THE GARDENS AT NORTH CAREFREE PRE DEVELOPMENT GRADING AND EROSION CONTROL PLAN EL PASO COUNTY, STATE OF COLORADO

Markup Summary

1 **TYPICAL SECTION - PUBLIC STREET**
 SCALE: NTS (URBAN LOCAL)

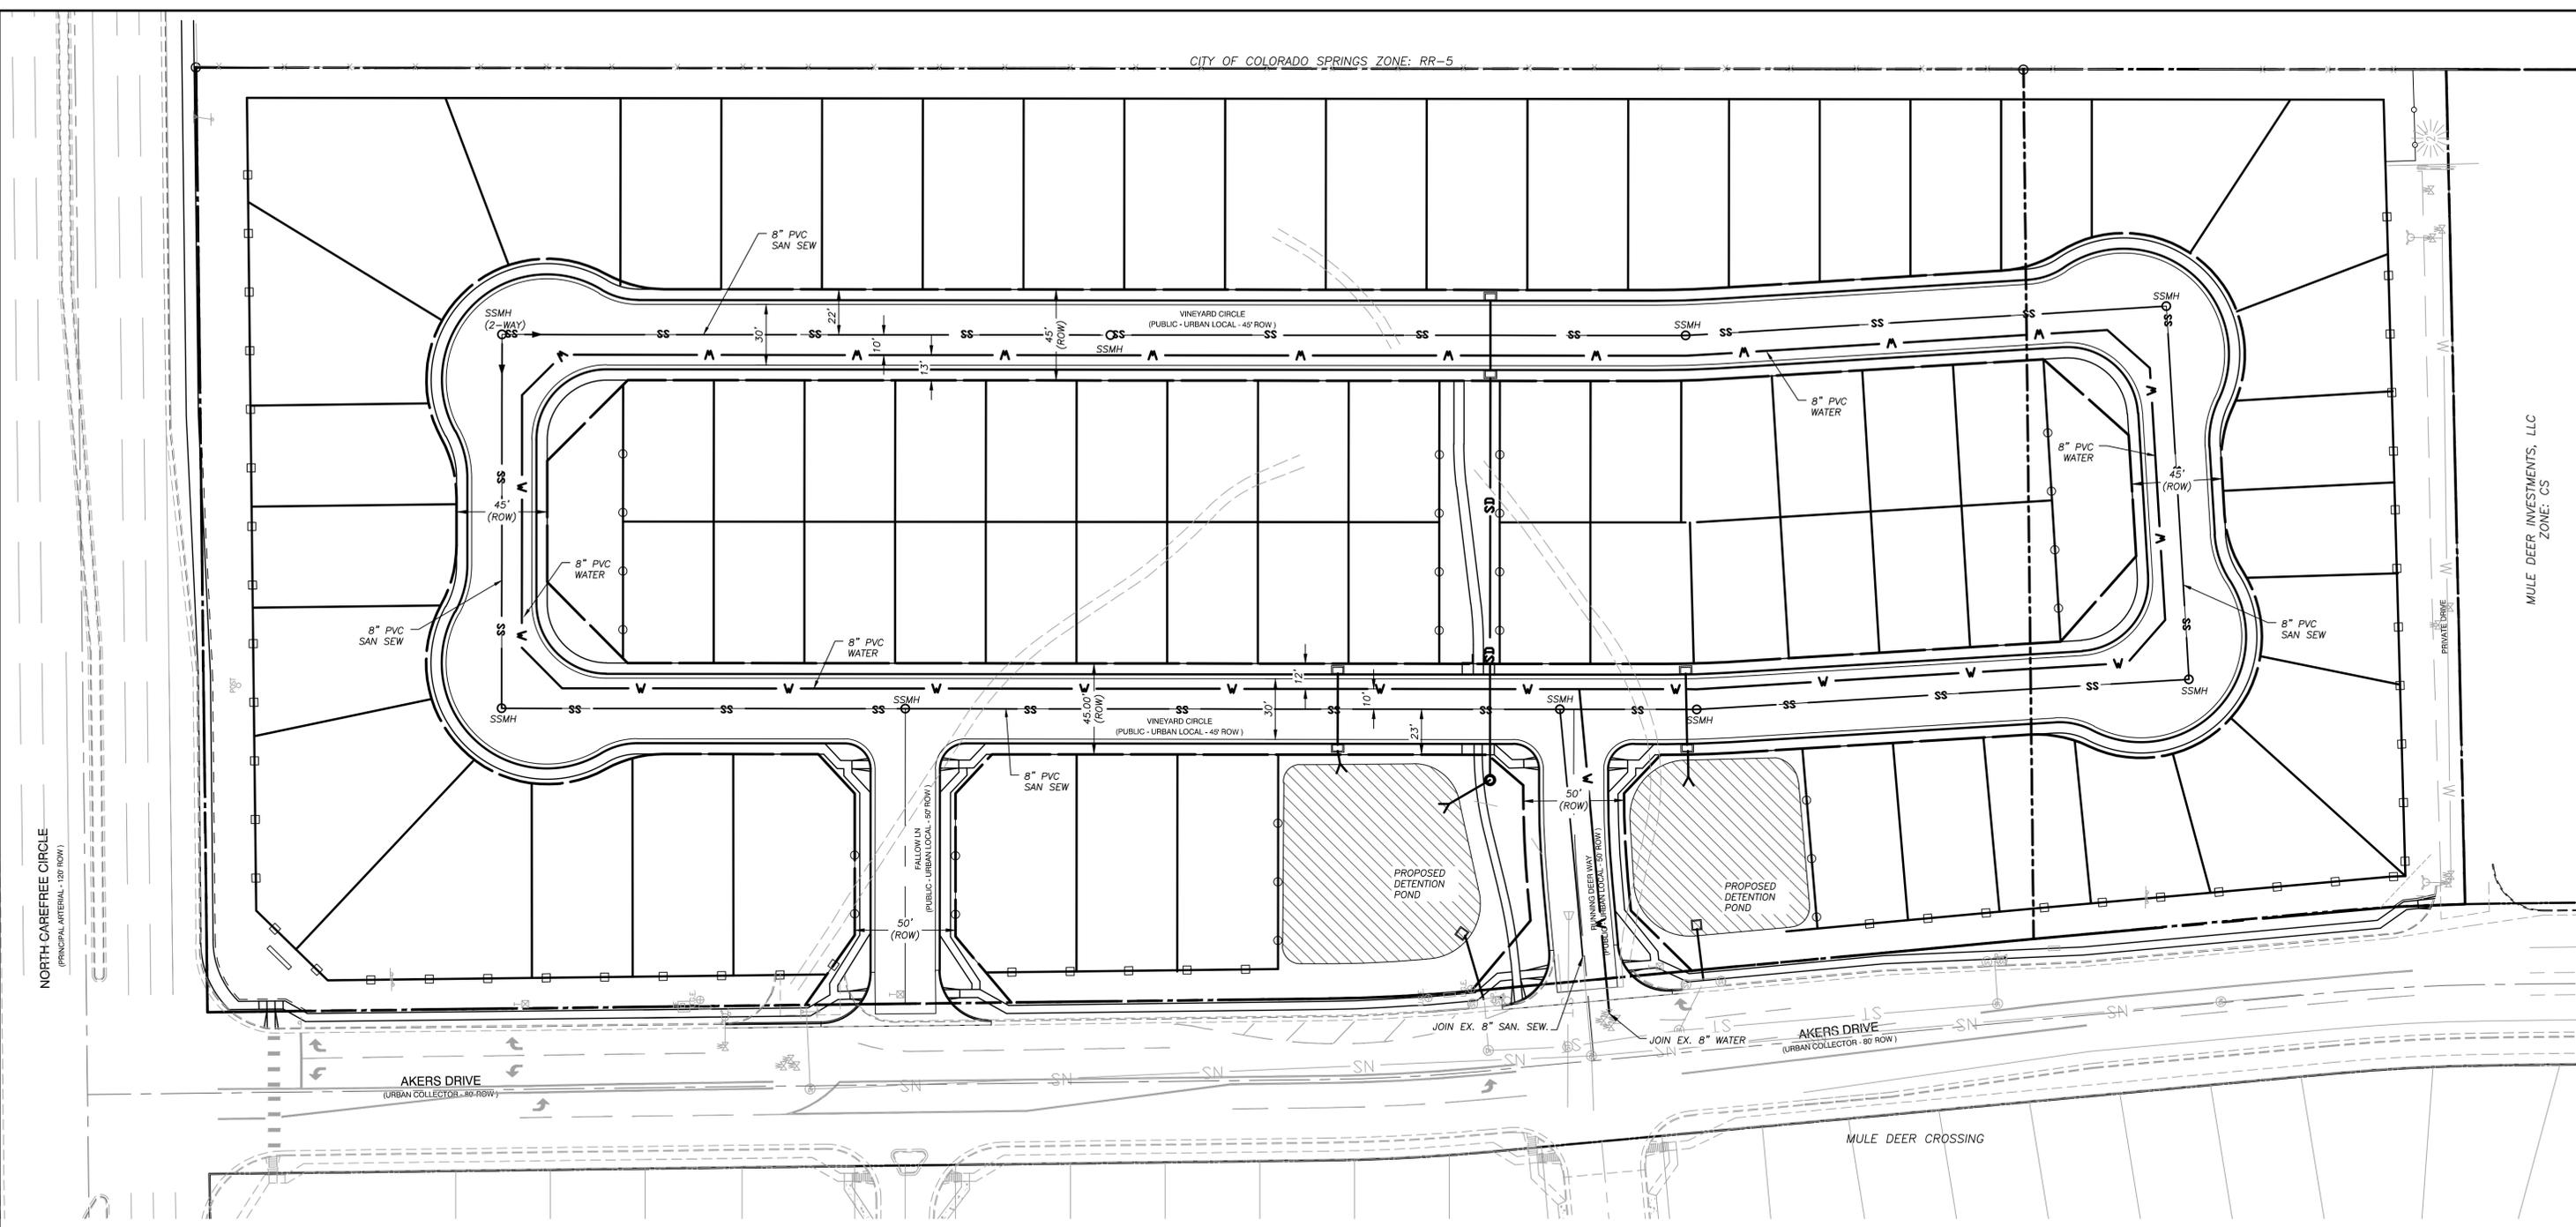
Contours shown on the grading plan are to finished grade. Define the rough grade limits in the typical street section. See examples below
